# KIRKLEES METROPOLITAN COUNCIL INVESTMENT & REGENERATION SERVICE

Reference No:	<b>2023/65/91531/W</b>
Site Address:	Edgerton Villa, 22/24, Edgerton Road, Edgerton, Huddersfield, HD3 3AD
Description:	Listed Building Consent for alterations to convert offices to 7 flats (within a Conservation Area)
Recommending Officer:	William Simcock

# **Officer Report – 2023/91531**

## **Edgerton Villa, Edgerton Road – Listed Building Consent**

GROUND FLOOR PLAN
 24 Edgerton Road, Huddersfield. Scale 1:100
 ANTHONY DANN ASSOCIATES

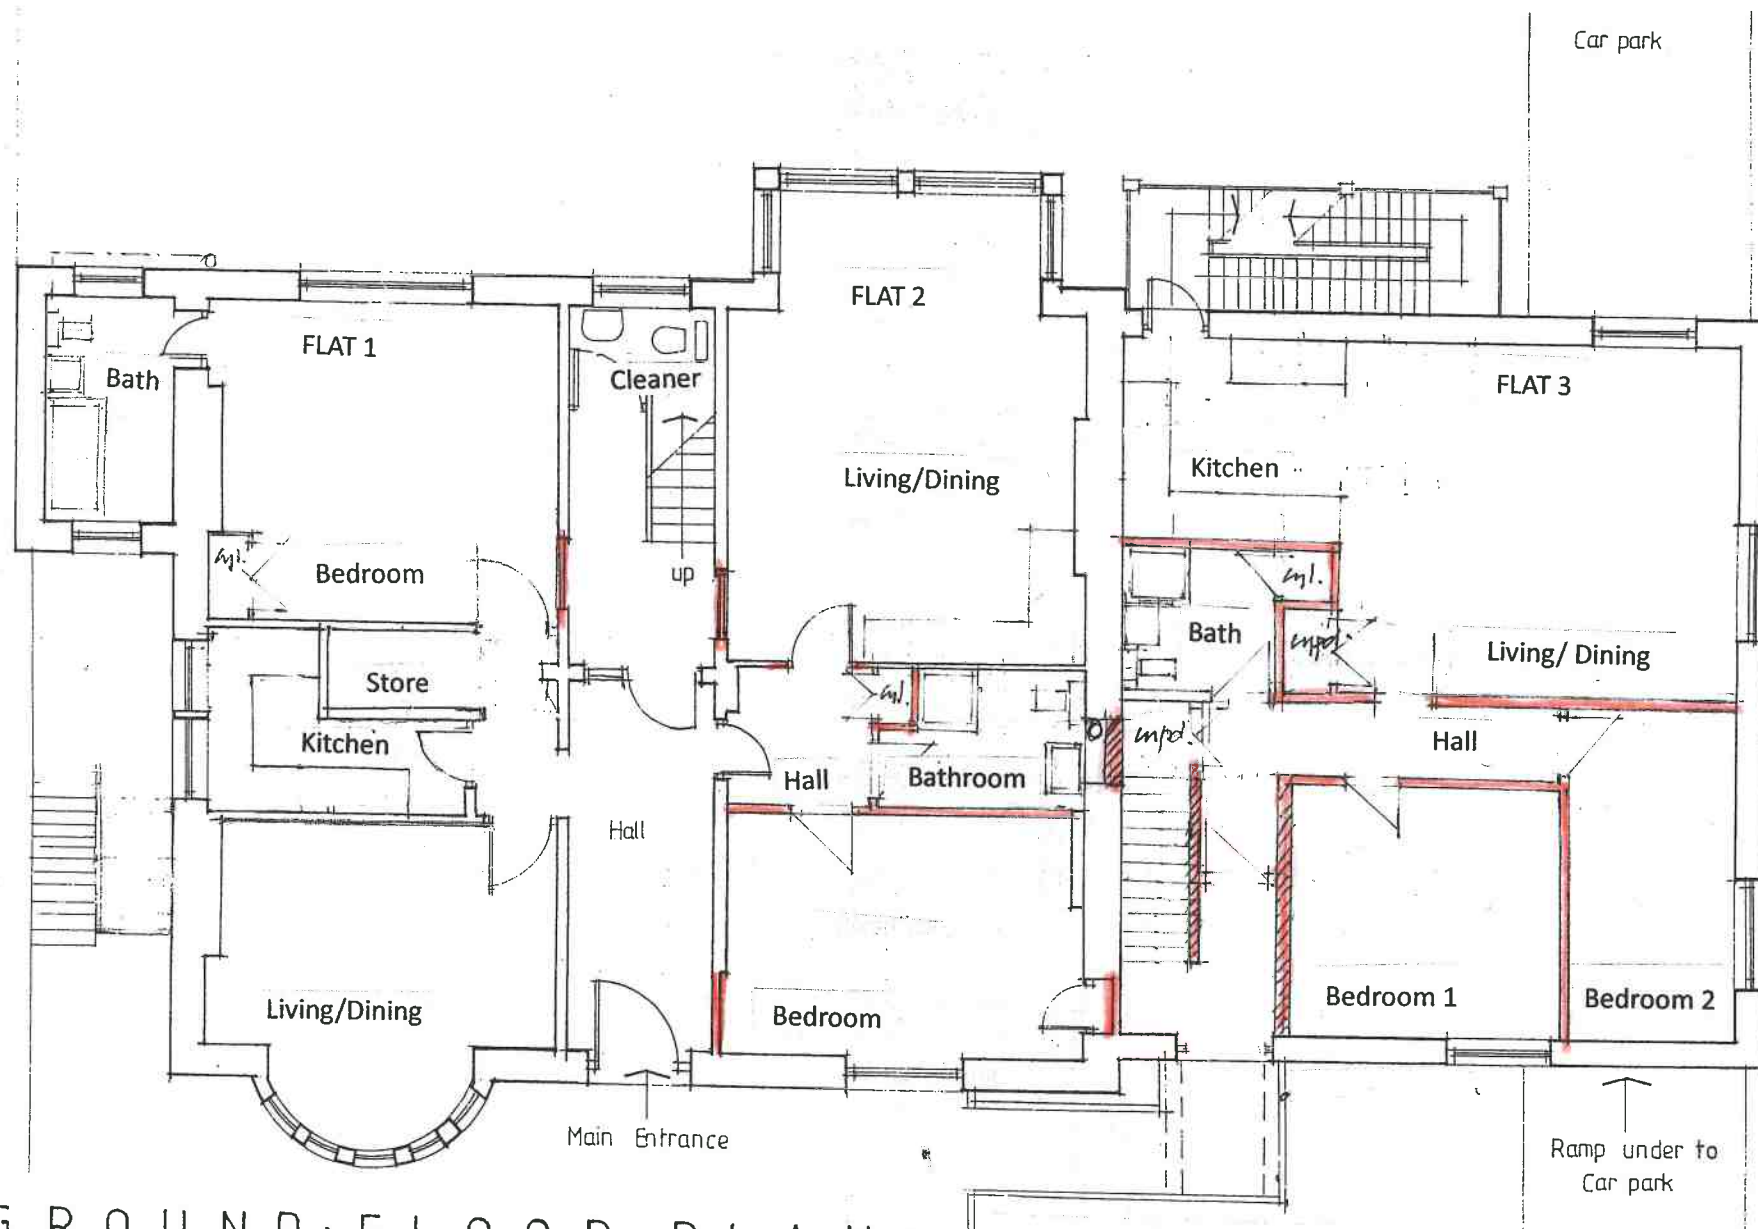
The application form states that no changes are proposed to the existing windows, however, this has been amended and new windows are shown on the proposed drawings – one on the rear of the lower ground floor level, and the replacement of a modern window on the front elevation above the front door. It is recommended that a condition is applied requiring their details to replicate existing windows.

The living / dining room ceiling in Flat 2 is ornate and must remain exposed, without a suspended ceiling installed below. The applicant confirmed that this will be retained, with an intumescent doorway treatment applied to achieve the necessary fire protection. It is recommended that a condition is applied requiring details to be submitted for approval.

9. Notwithstanding the submitted plans and information, the proposed new window of the proposed flat 2, bedroom on the ground floor front elevation (shown on the proposed ground floor plan) shall replicate the existing window of the same room, albeit with a deeper section to accommodate slim double-glazed units with a 4:8:4 section and black spacers. Visible trickle vents shall not be permitted. The development shall thereafter be completed in accordance with the approved details and thereafter retained.

13. Details of the intumescent paint treatment to the ceiling of the living/ dining room in Flat 2 shall be submitted to and approved in writing by the Local Planning Authority before painting is carried out. Details shall include the finish, colour and texture. Painting shall be undertaken in accordance with the approved details.
